SCOPING OPINION:

Proposed Lostrigg Solar

Case Reference: EN0110004

30 July 2024

Table front view - 3 modules in portrait
scale 1:200

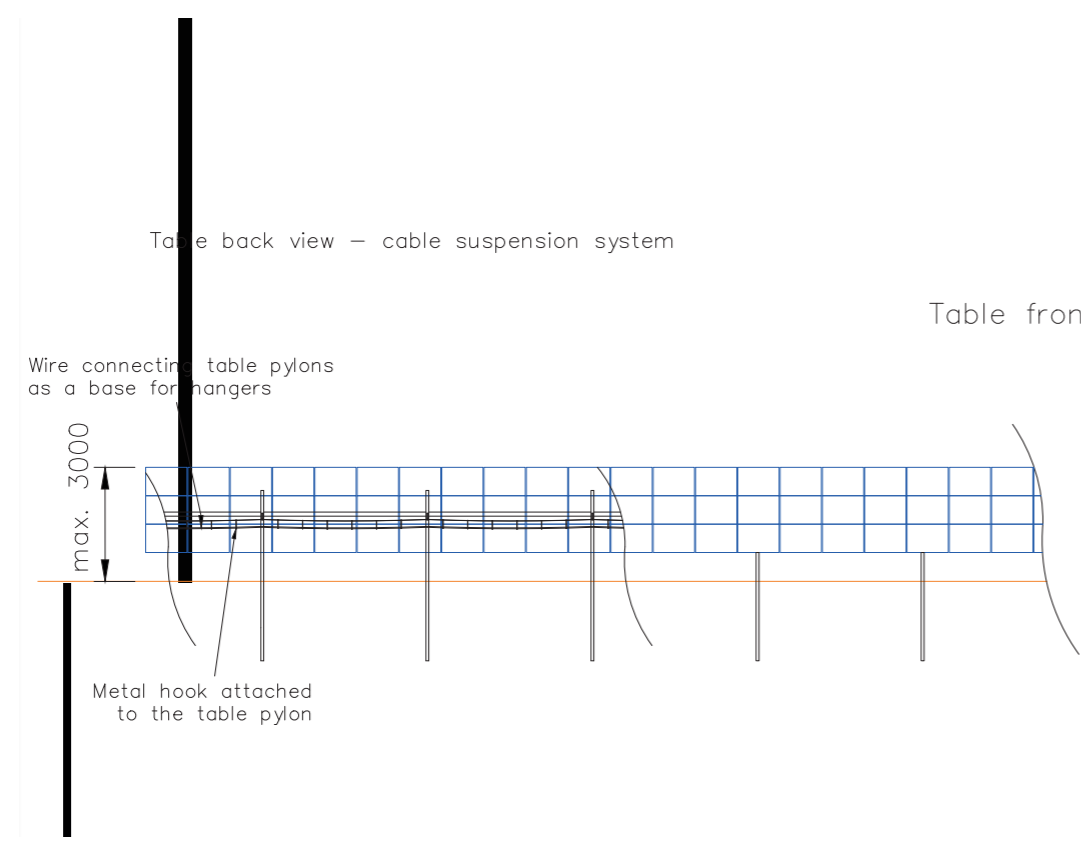
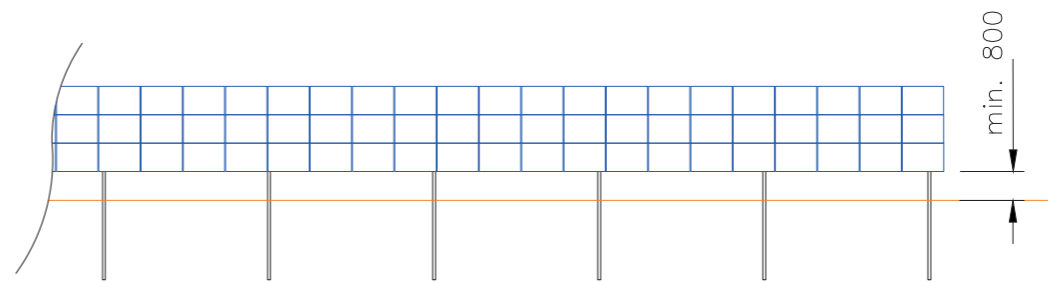
ID	Ref	Description	Inspectorate's comments
21.1	Table 2.1	Solar panels - key parameters	Height – this sentence states that panel heights are 'between 0.8m' but this sentence has not been completed.

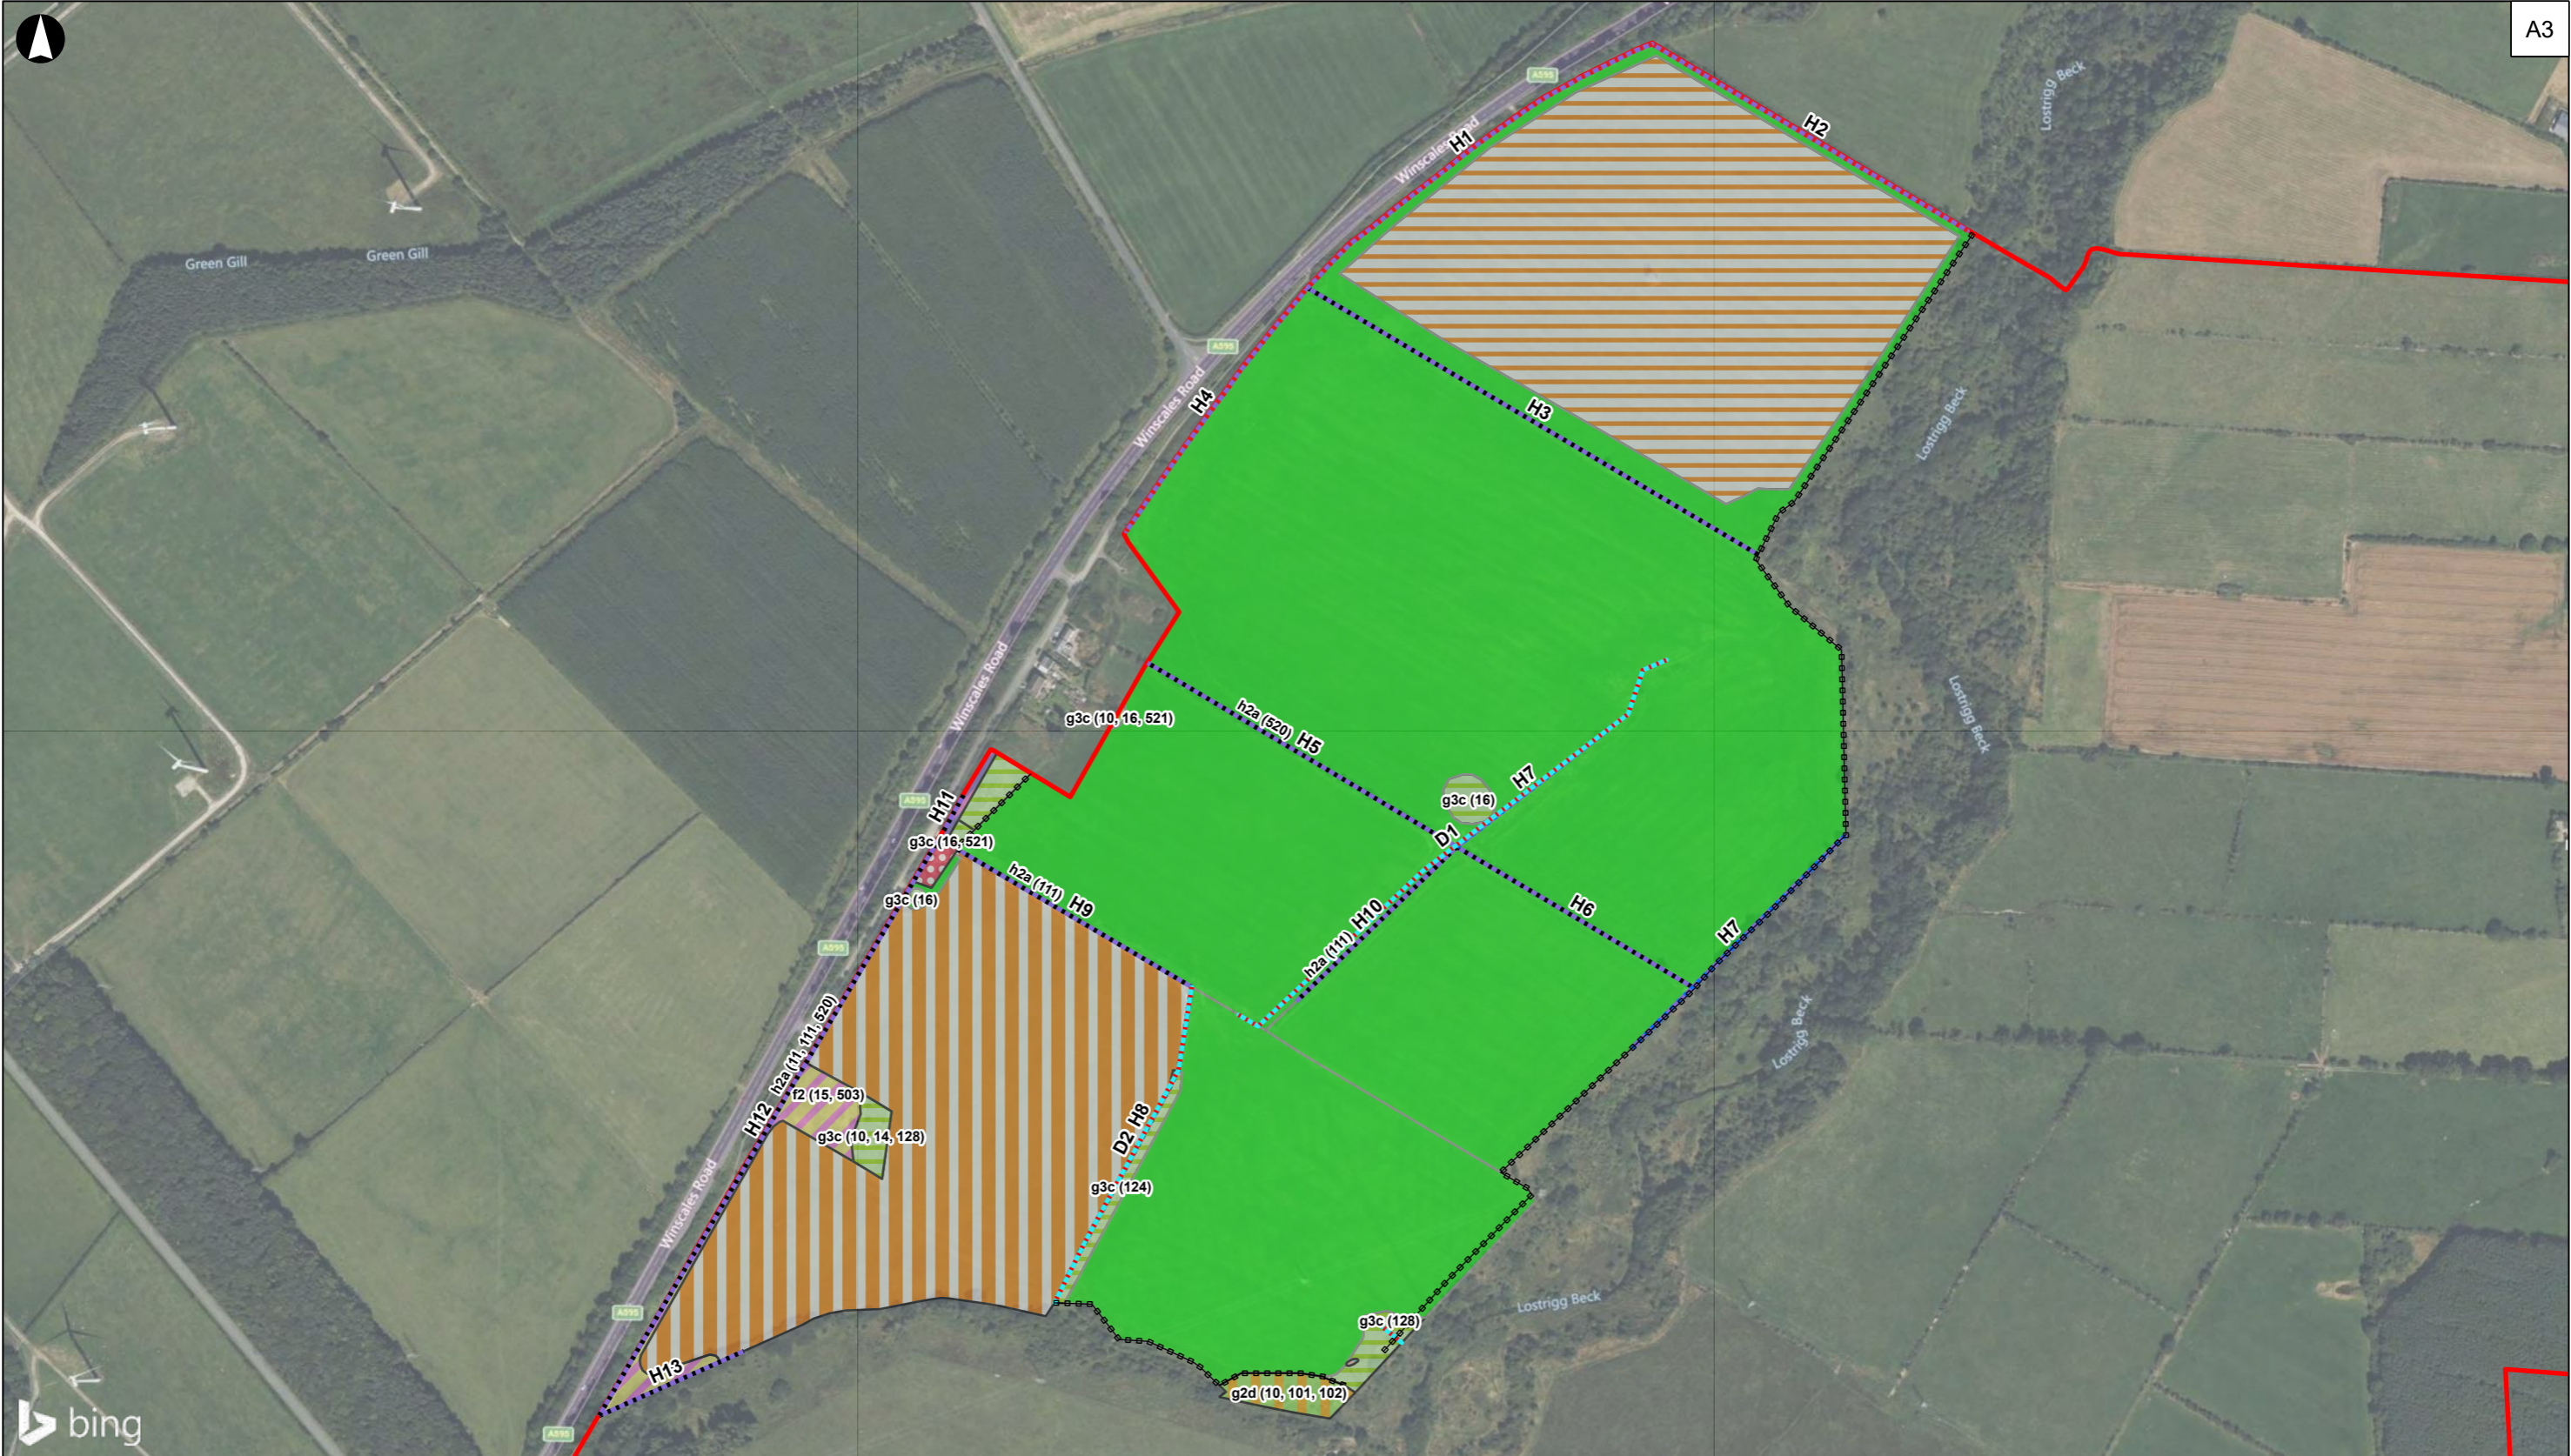
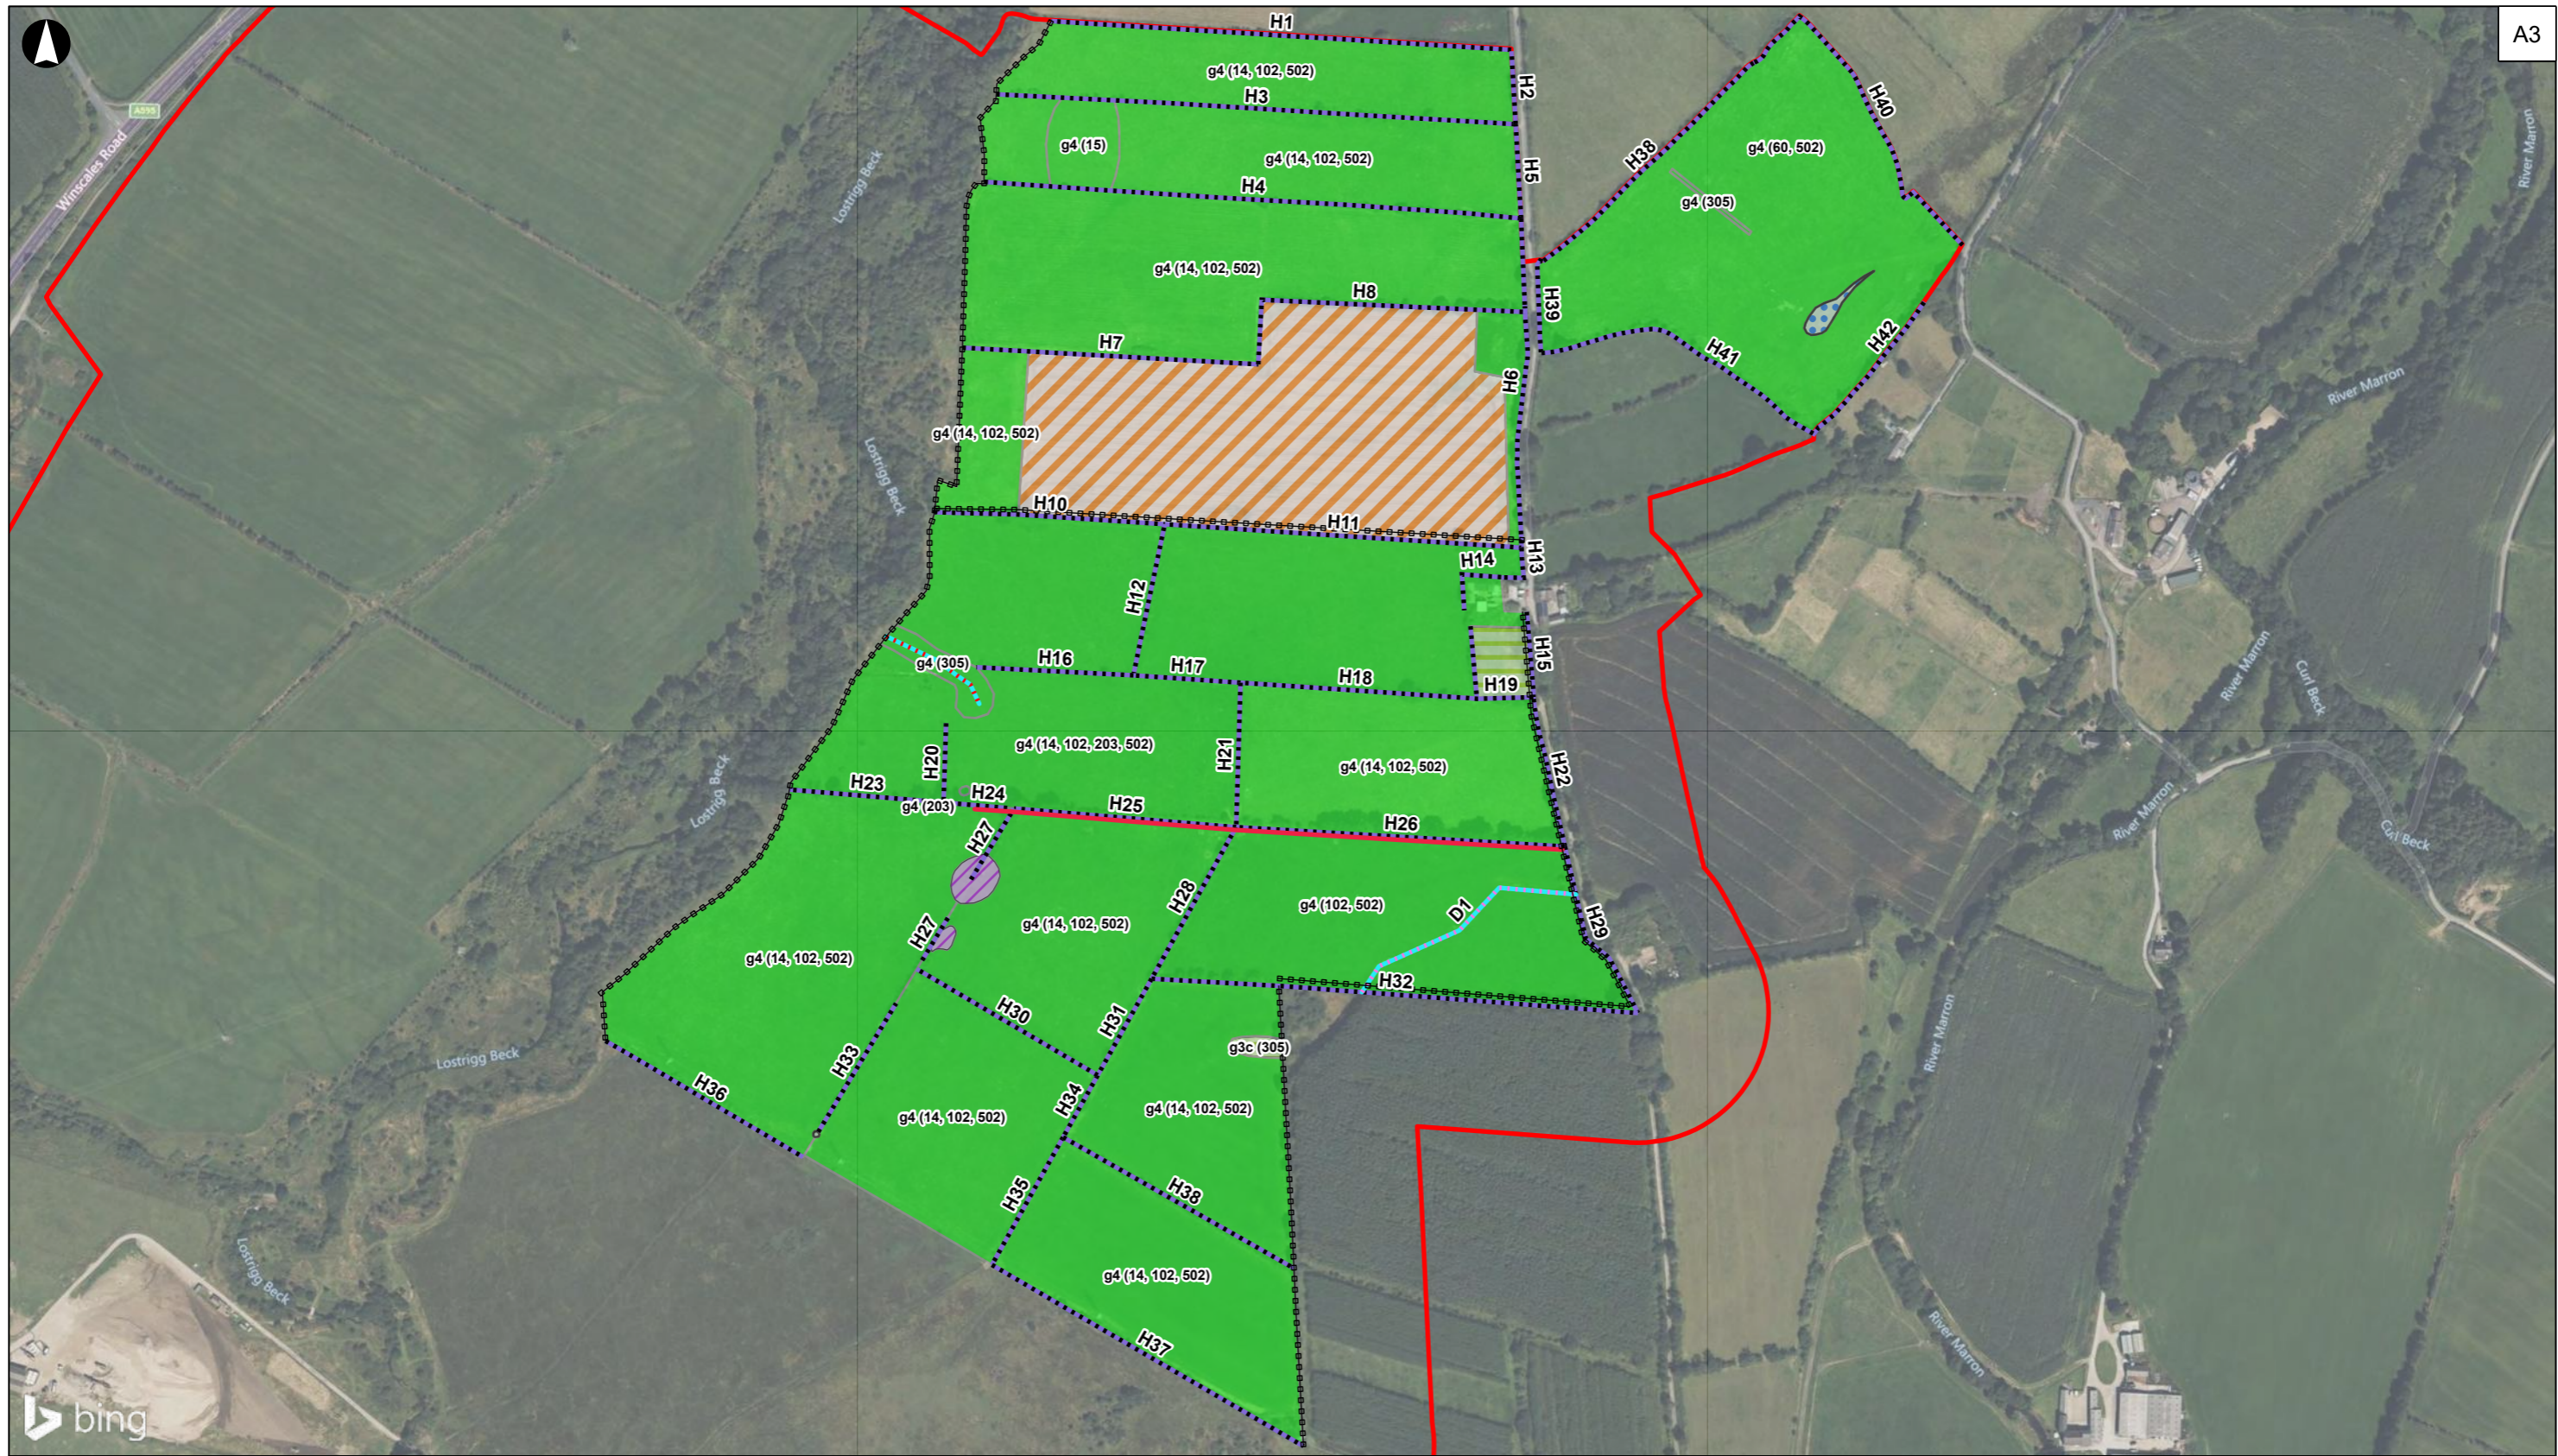
ID	Ref	Applicant’s proposed matters to scope out	Inspectorate’s comments
331	Paragraph 7.8.2.5 and Table 7-7	Effects on priority habitats during operation	Scoping Report Figure 7.4.1 to Figure 7.4.5 identify areas of priority habitat and show this as ‘h2a hedgerow’. The Scoping Report refers to purple moor grass and rush pasture as Priority Habitat (A35), yet these areas do not appear to be shown on the supporting figures. The Inspectorate does not, therefore agree to scope this matter out at this stage and considers that the ES should apply a consistent and accurate approach between the main report and figures and assess significant effects to these habitats where they are likely to occur.
332	Paragraph 7.8.2.5 and Table 7-7	Effects on the following species during operation: <ul style="list-style-type: none"> • Badger • Otter • Water vole • Amphibians • Reptiles • Fish • Invertebrates Protected and notable plants	These species are proposed to be scoped out on the basis that no direct effects are anticipated, and indirect effects can be managed by the use of embedded design measures and the outline Landscape and Environmental Management Plan (oLEMP). The Inspectorate agrees that significant effects are unlikely to occur during operation and these may be scoped out for this phase.

338	Paragraph 7.8.1.3 and Figure 7.4.1 to 7.4.5	Priority Habitats	The Scoping Report acknowledges that the Proposed Development may affect areas of Priority Habitat which are present on site. These areas do not appear to be shown on the supporting figures. The ES should provide a plan which shows the location of all areas of priority habitat which may be affected by the Proposed Development. In their response, the Environment Agency have commented that other types of priority habitats are located in the area such as upland flushes, fens and swamps. The ES should include all areas of Priority Habitat on relevant figures.
339	Table 7-4	River Derwent and Bassenthwaite Lake Special Protection Area, Solway Firth SAC and River Ehen SAC.	It is noted that Table 7-4 does not include all qualifying species which are included in the site designations. The ES should ensure that all qualifying features for all designated sites are included. The Applicant should take note of comments provided by the Environment Agency, in their response to the Scoping Report.
